Reg No.: 24/0251
Your Reference: SSD-59006709
To: NSW PLANNING & ENVIRONMENT

Feedback on proposed changes to planning controls

Controlled Activity: OLS ENQUIRY
Location: 28-32 BOURKE ROAD ALEXANDRIA
Council: NSW PLANNING & ENVIRONMENT

Drawing Title
NORTH ELEVATION

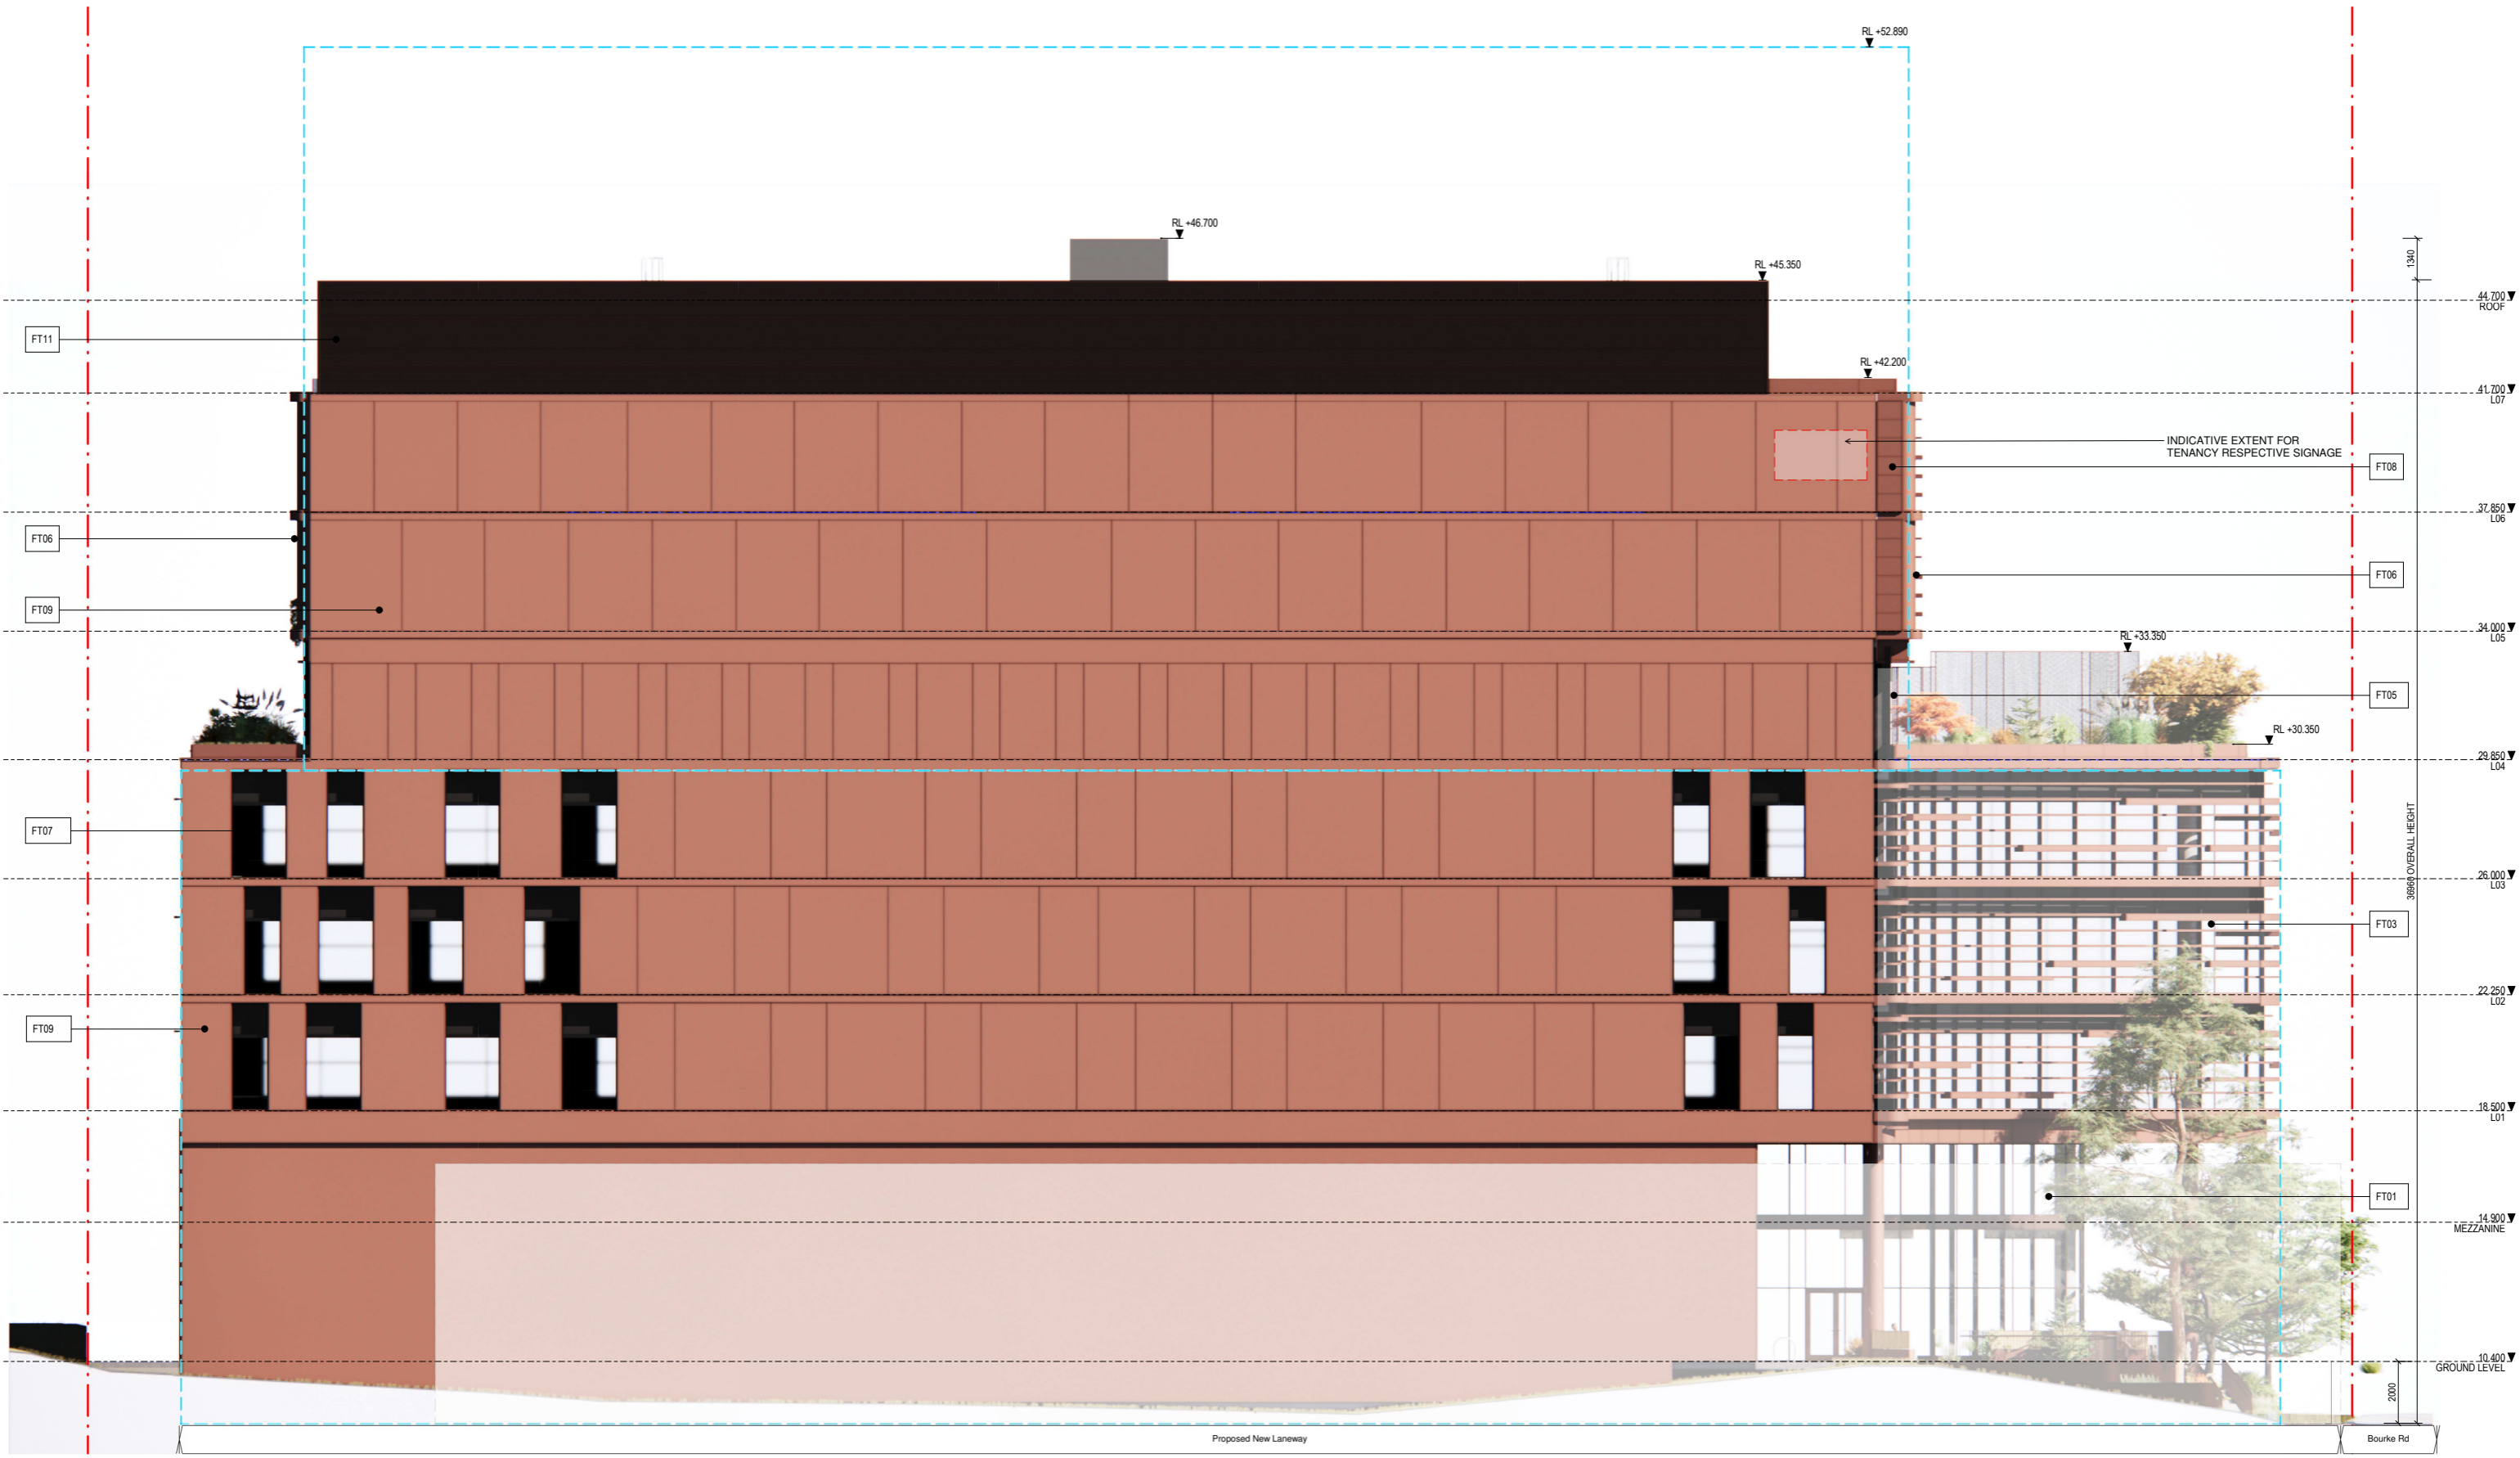
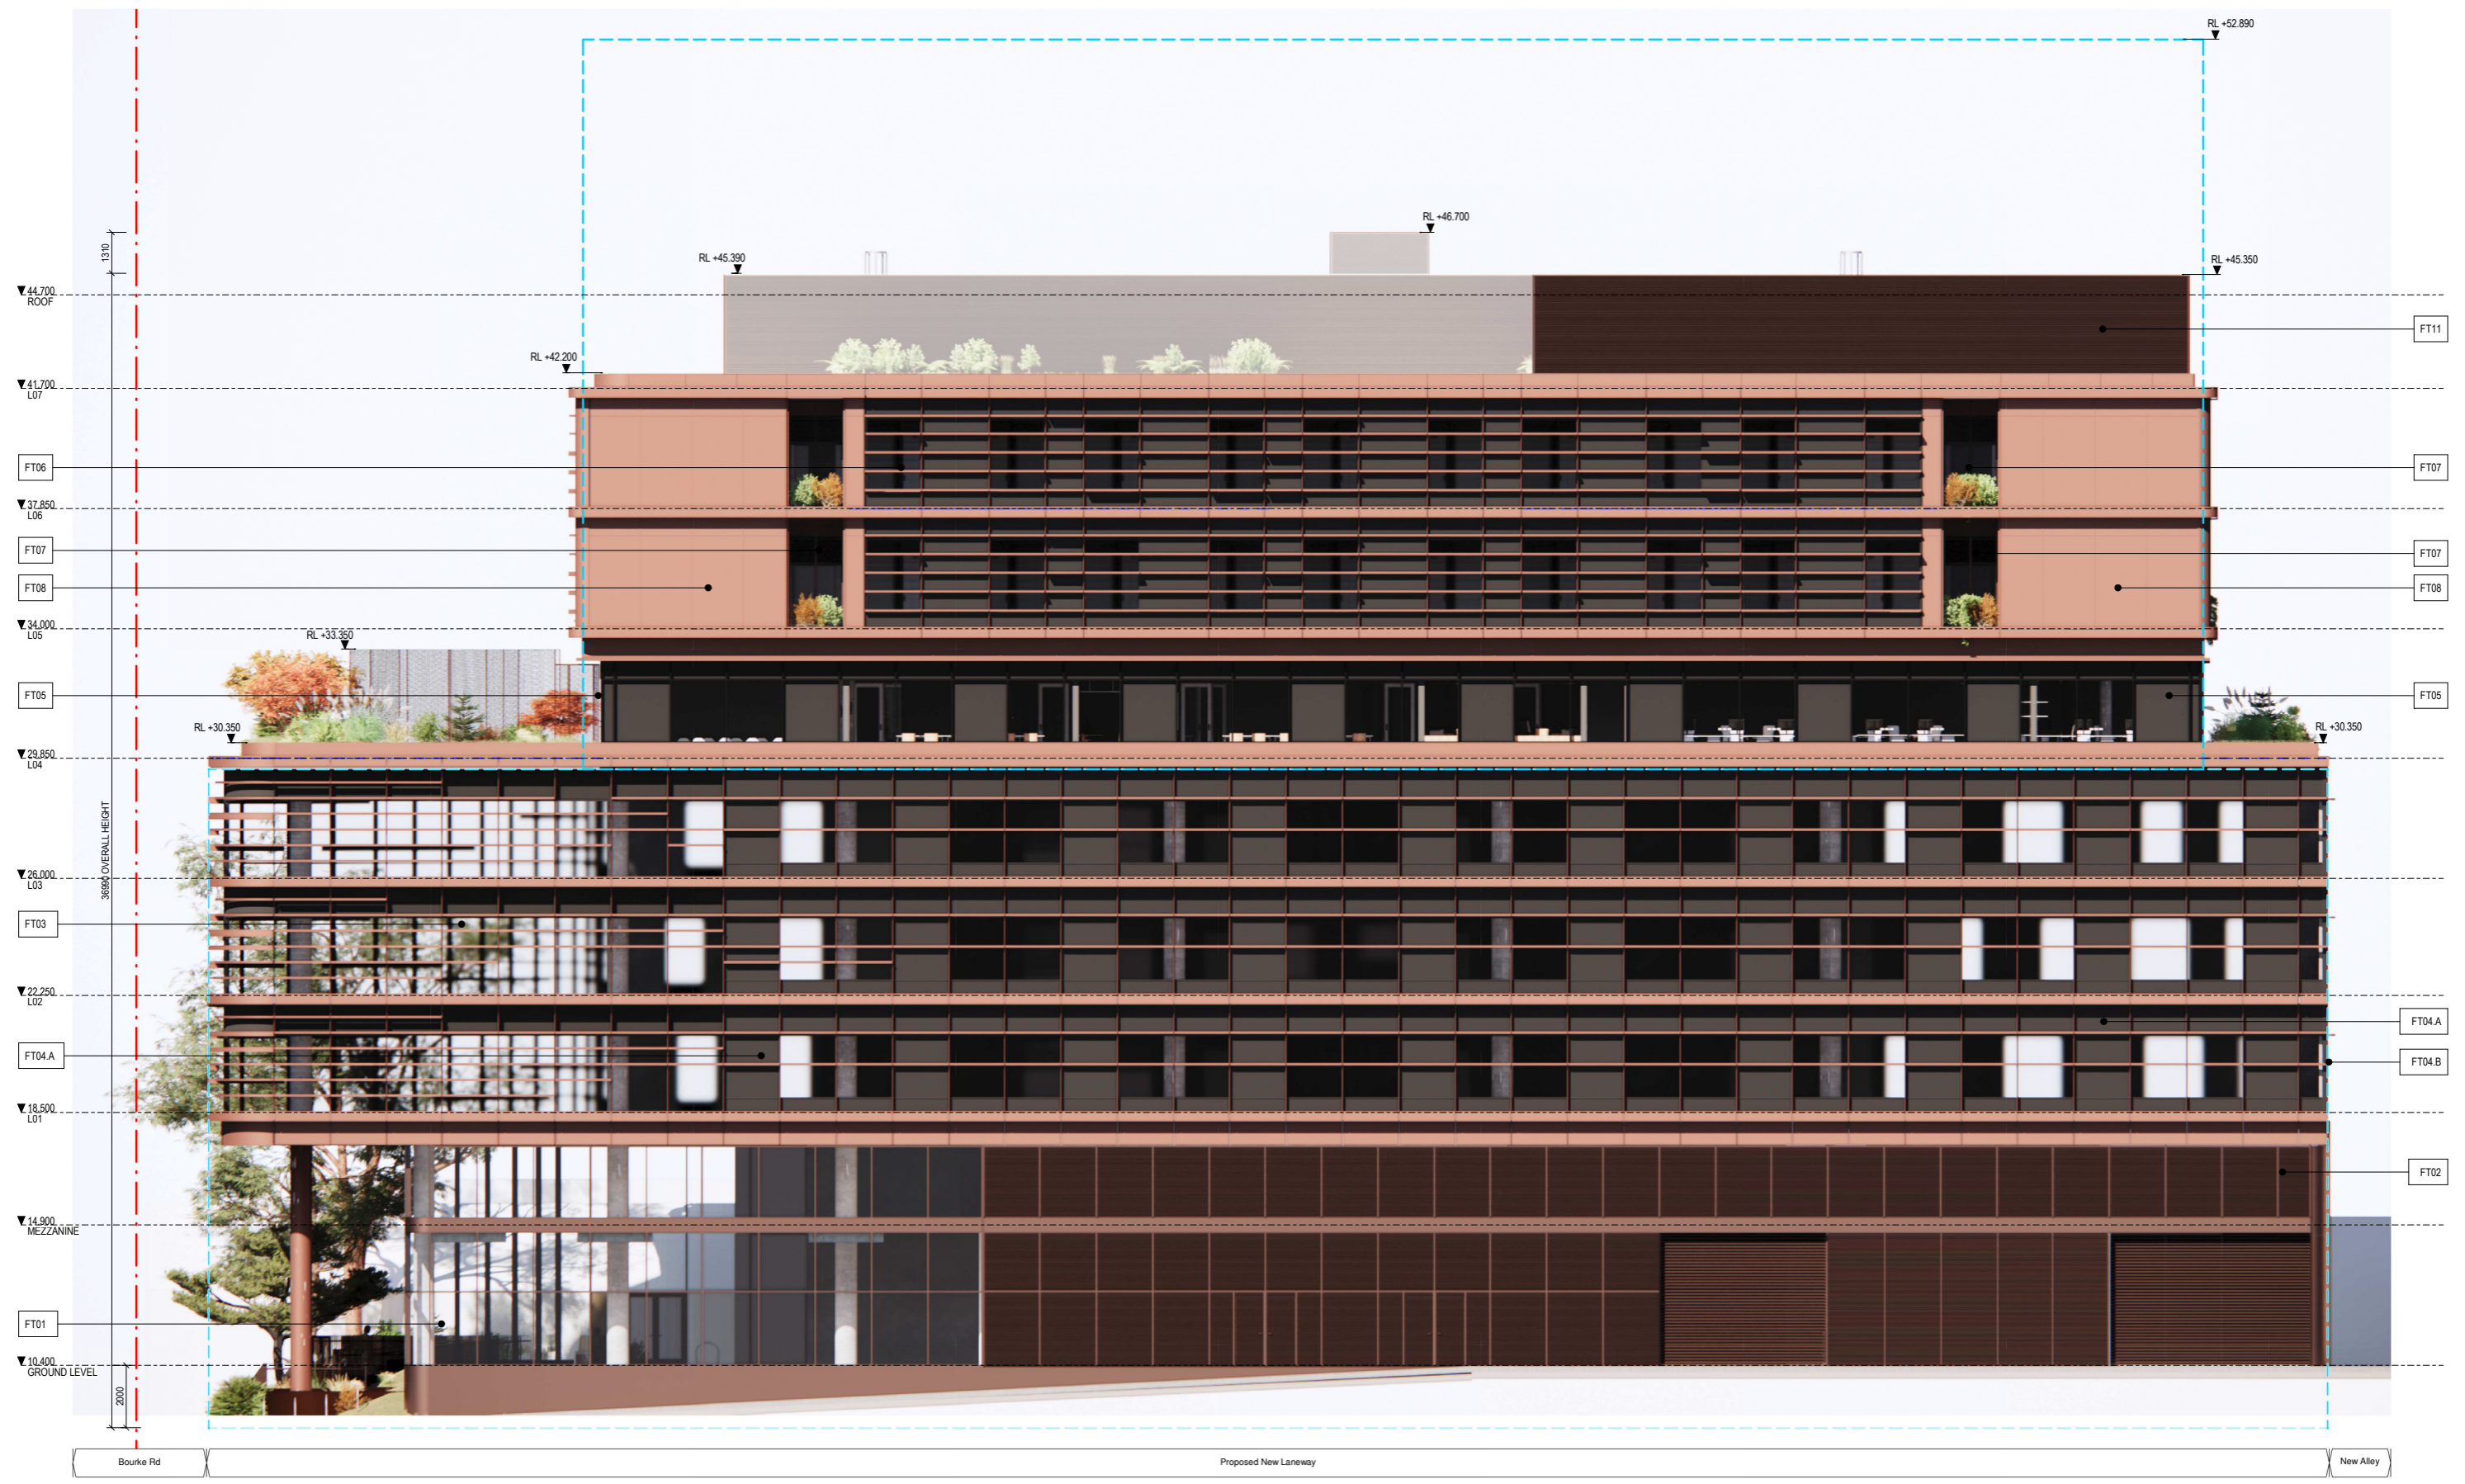
The height of the Obstacle Limitation Surface (OLS) for Sydney Airport over the site is 51m AHD.

I note that the tallest building in the proposed development has a maximum height of 53.41m AHD. Any proposed development designed to be taller than 51m AHD, would be considered a controlled activity and be subject to the Federal Airports (Protection of Airspace) Regulations 1996.

Construction cranes may be required to operate at a height significantly higher than that of the proposed development and consequently, may not be approved under the Airports (Protection of Airspace) Regulations 1996.

Sydney Airport advises that approval to operate construction equipment (ie cranes) should be obtained prior to any commitment to construct.
